# FILE NOTE

**Re: Meeting – GPT Site – Mamre Road Precinct**

**Re: Lot 59 DP 259135, Mamre Road, Kemps Creek, NSW**  
**Drainage Considerations for E2 Zone Realignment**

**Re: Lot 59 DP 259135, Mamre Road Kemps Creek  
E2 Corridor and Waterway Corridor**

E2 CORRIDOR ALIGNMENT PLAN
SCALE 1:500

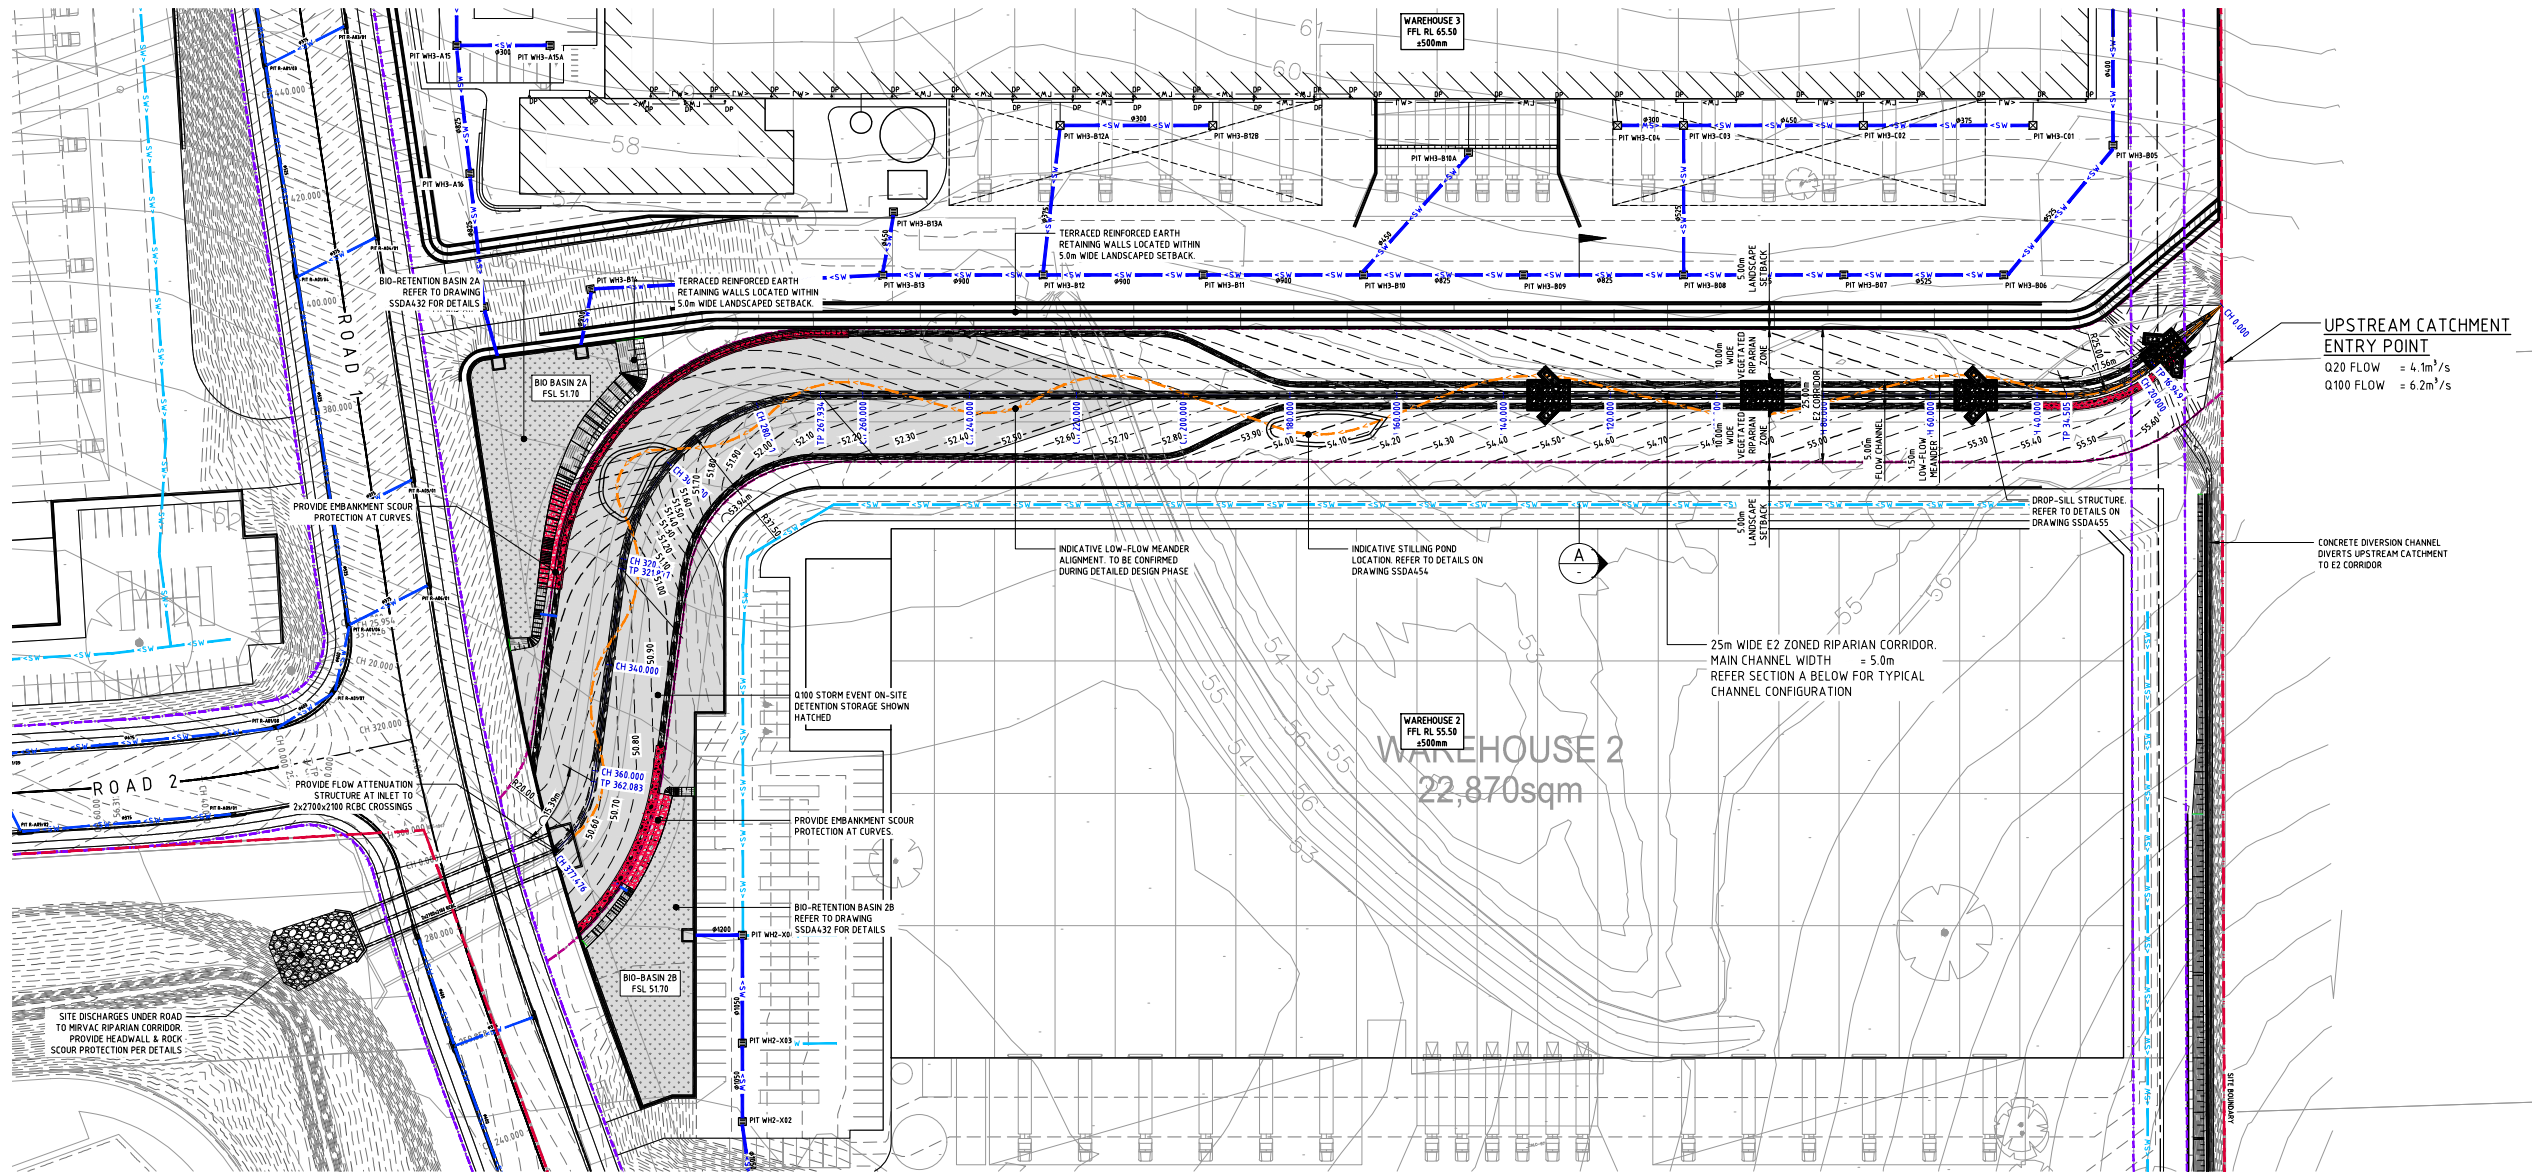
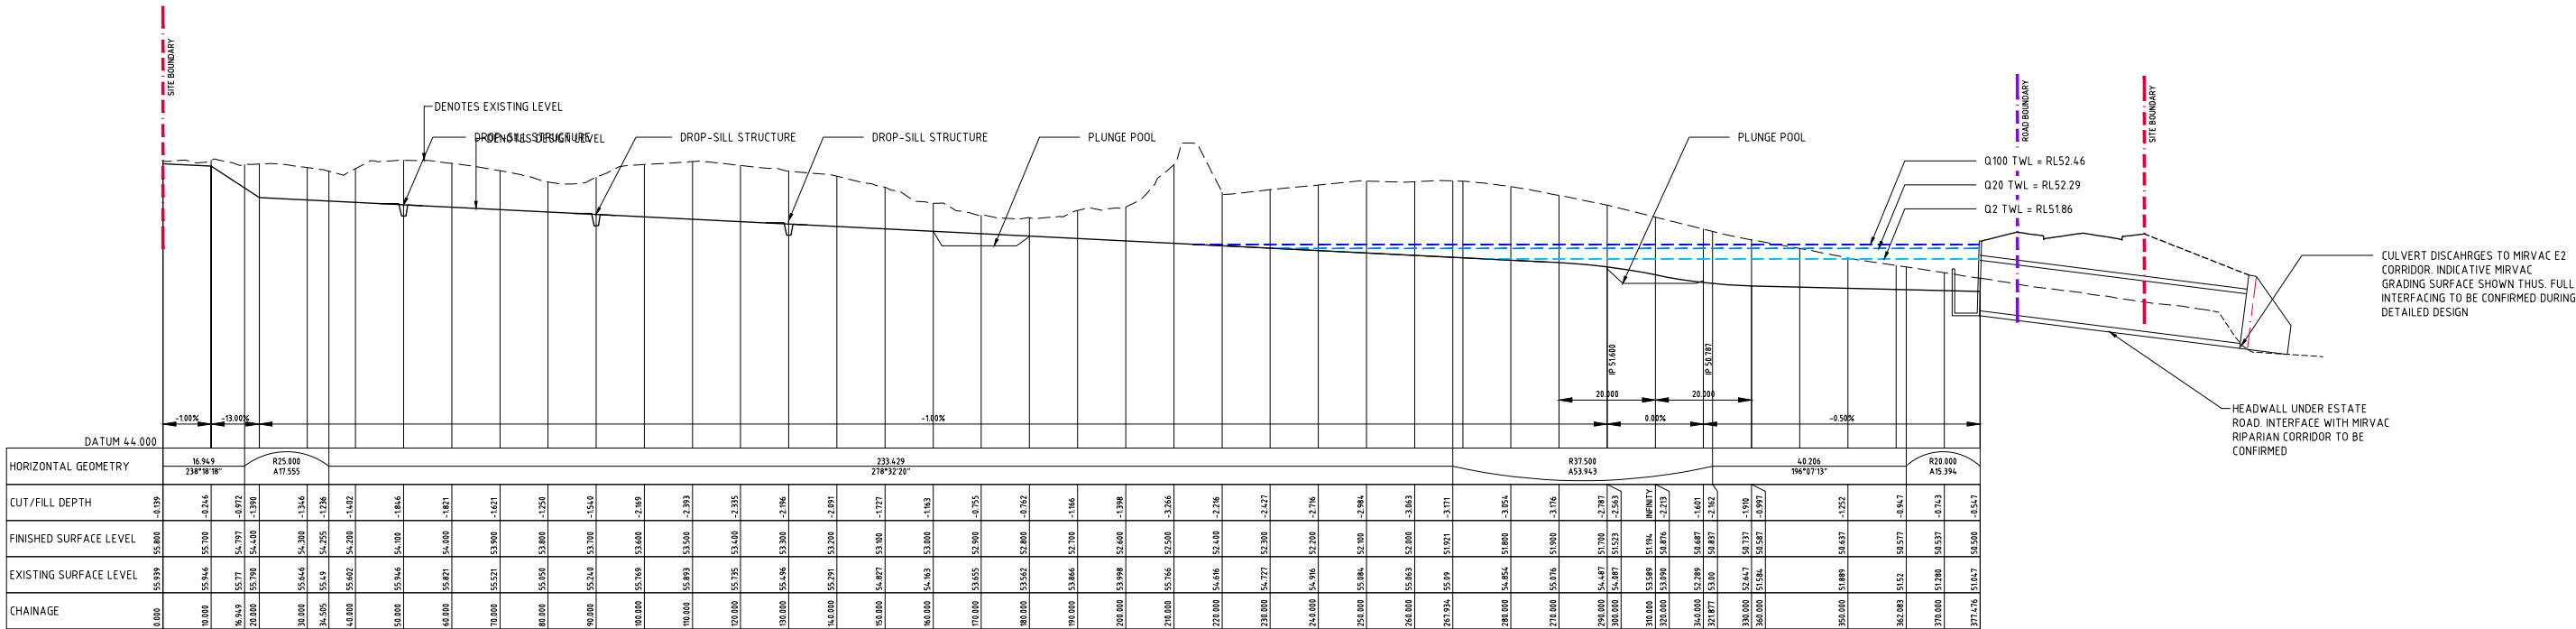
- NRAR is in general agreement that the proposed reconstructed watercourse within the GTP site can be realigned. Realignment should not include 90 degree sharp meanders. The alignment should mimic natural stream design.

- NRAR does not support the reduction in the corridor width from 40m to 20m in the upstream reach within the GPT site. It is noted that the reduction of stream ordering due to the removal of upstream 1<sup>st</sup> order watercourses is contrary to the requirements of the NRAR CAA Guidelines for riparian corridors.

Overall, we conclude that the existing watercourse can be realigned within the proposed 25m corridor. Further that the proposed 25m corridor meets the requirements of NRAR for a first order stream and that the 1% AEP flow of 4.4m<sup>3</sup>/s can be readily accommodated within the proposed naturalised channel.

For this project, noting the bankfull width of 5m, the minimum acceptable design radius of curvature as such is 15m. As shown in **Figure 1**, the proposed minimum radius is 25m, and where the larger change in direction is proposed (55m radius) the radius is noted to be 3.6 times greater than the minimum recommended curve radius.
